From: [Mau, Russell E \(DOH\)](#)
To: [Kelly Bacon \(CD\)](#)
Cc: [Holly Erdman](#); [Smits, Brenda M \(DOH\)](#); [DOH EPH DW ERO ADMIN](#)
Subject: RE: CU-22-00003 Brethren Frontier School - Notice of SEPA action and Public Hearing; Brethren Frontier School, 05033M, Kittitas County
Date: Thursday, November 3, 2022 11:52:25 AM

Subject: CU-22-00003 Brethren Frontier School - Notice of SEPA action and Public Hearing

□
 Exg.
 Well
 House

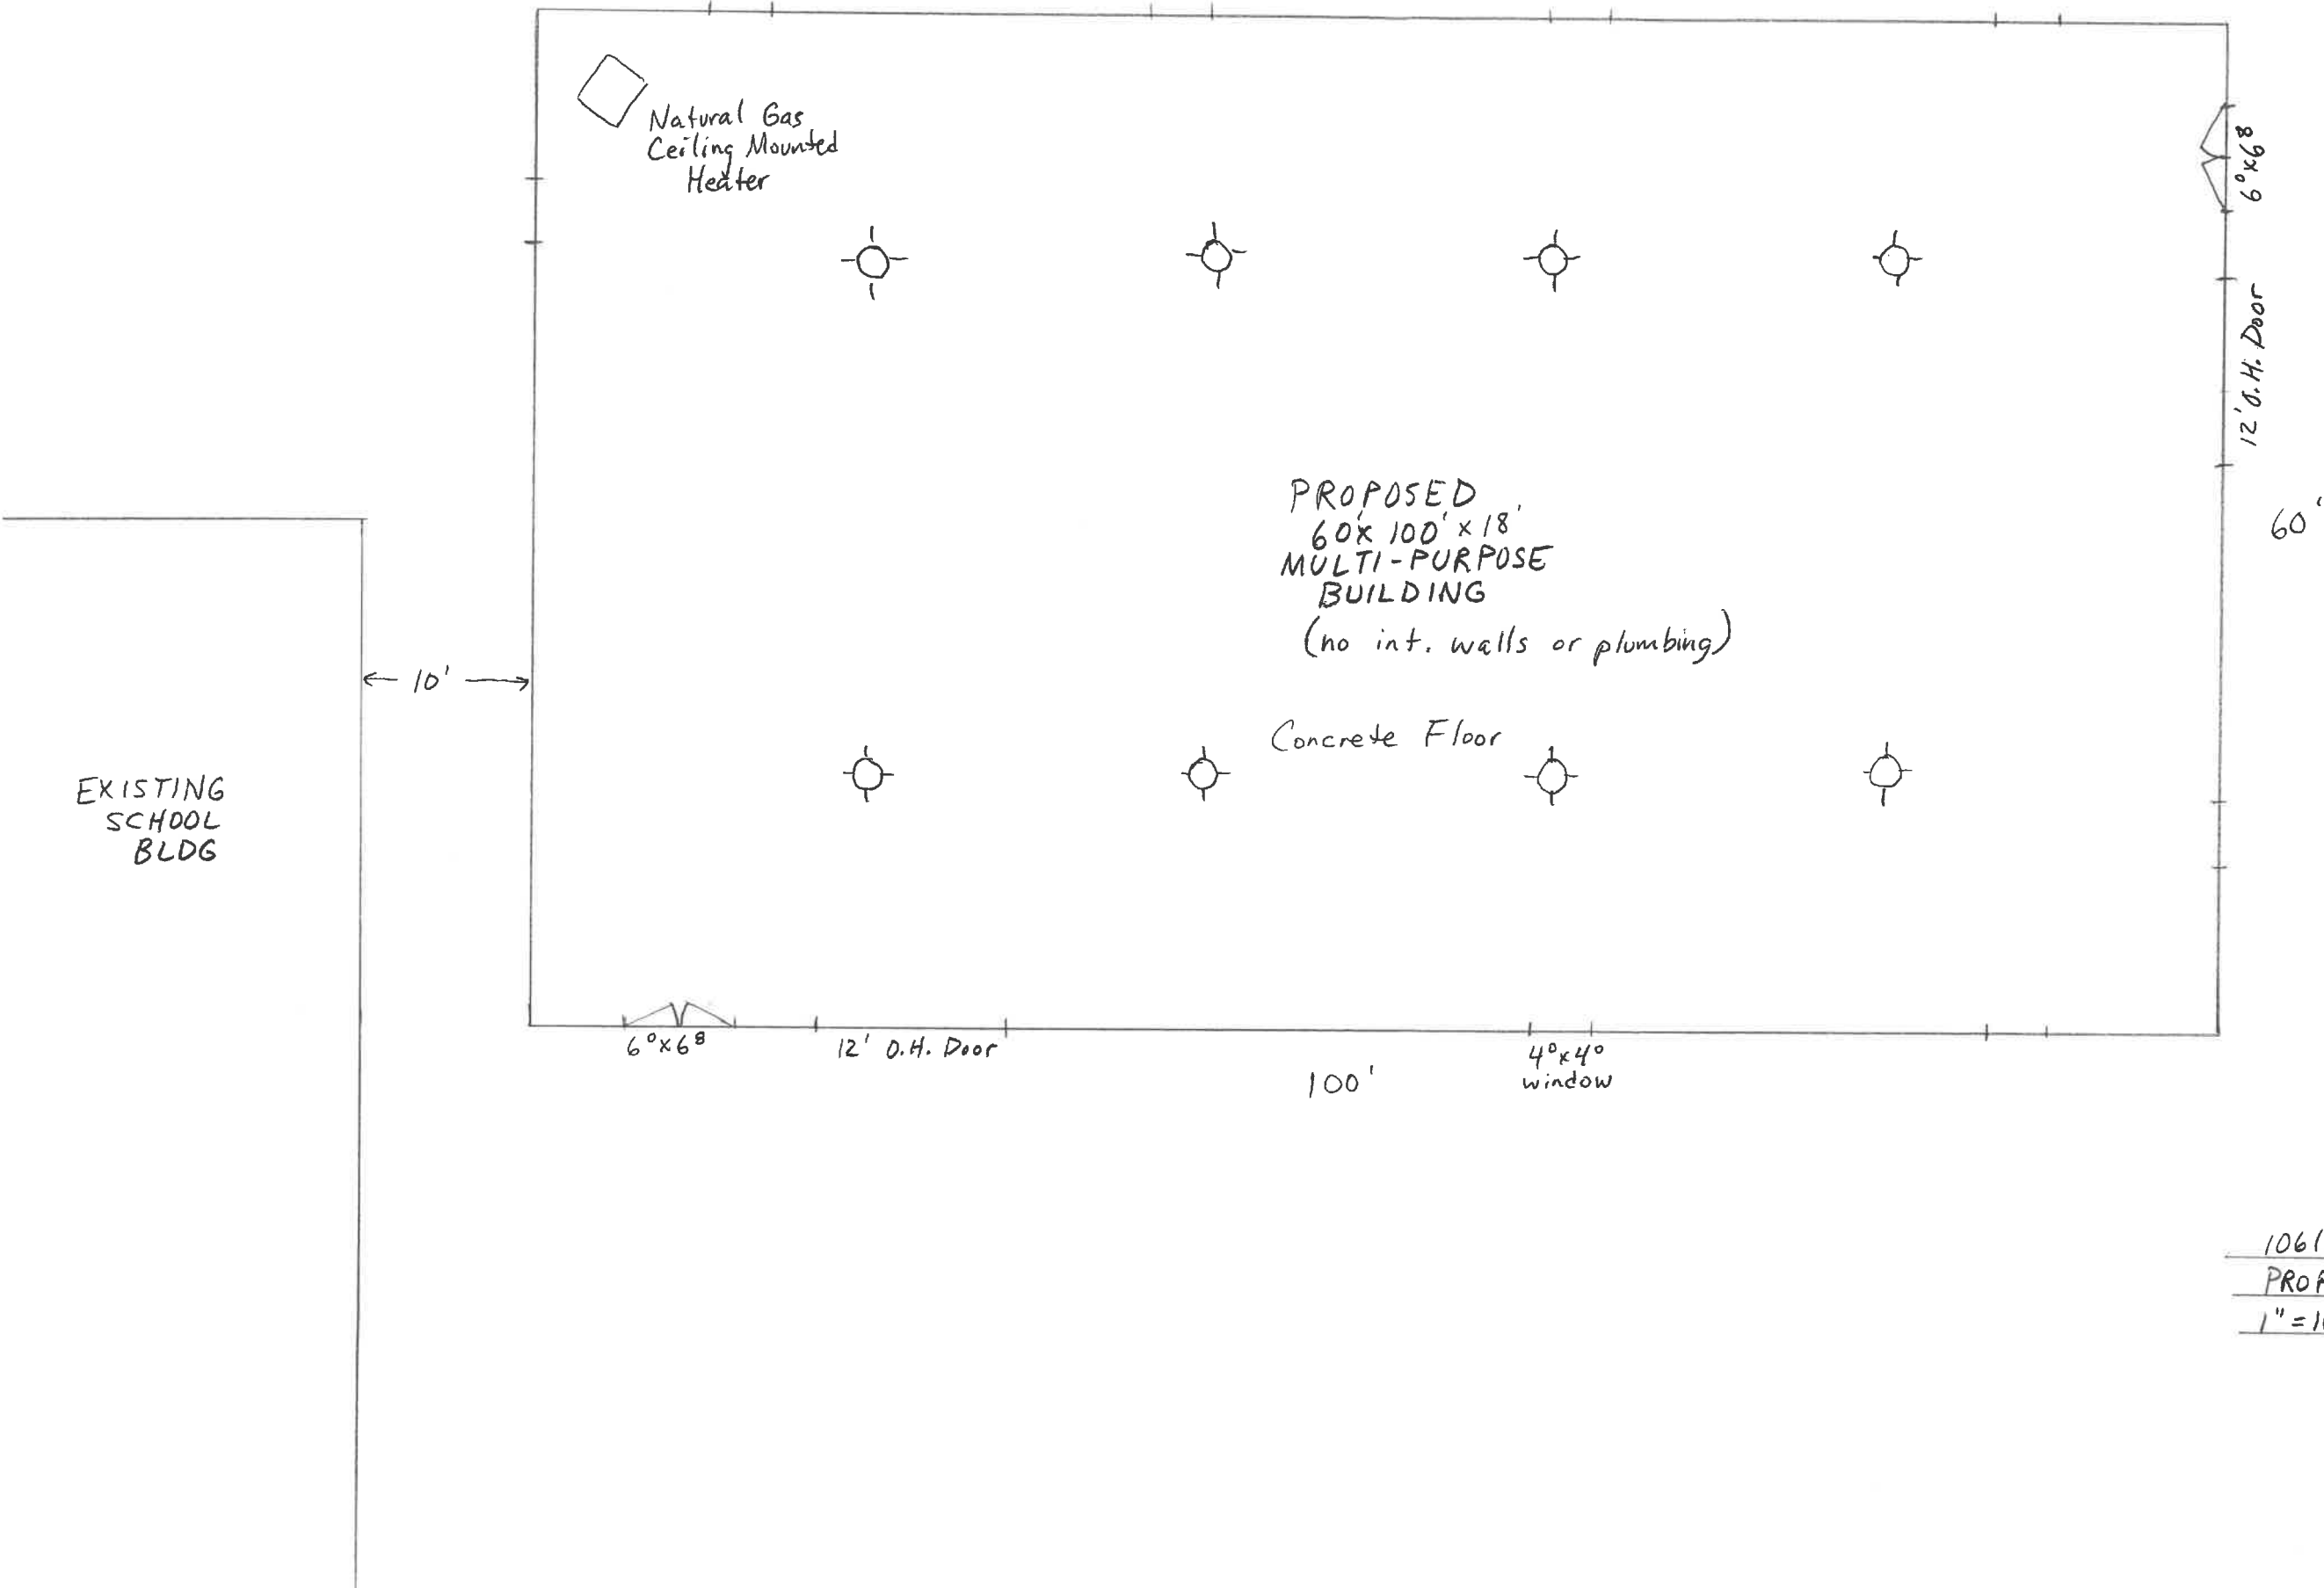
On this application, the applicant has indicated “water” (i.e., drinking water) is already available on-site – what is the source of that water: their own private well, their own well that is part of public water system, or from a public water system?
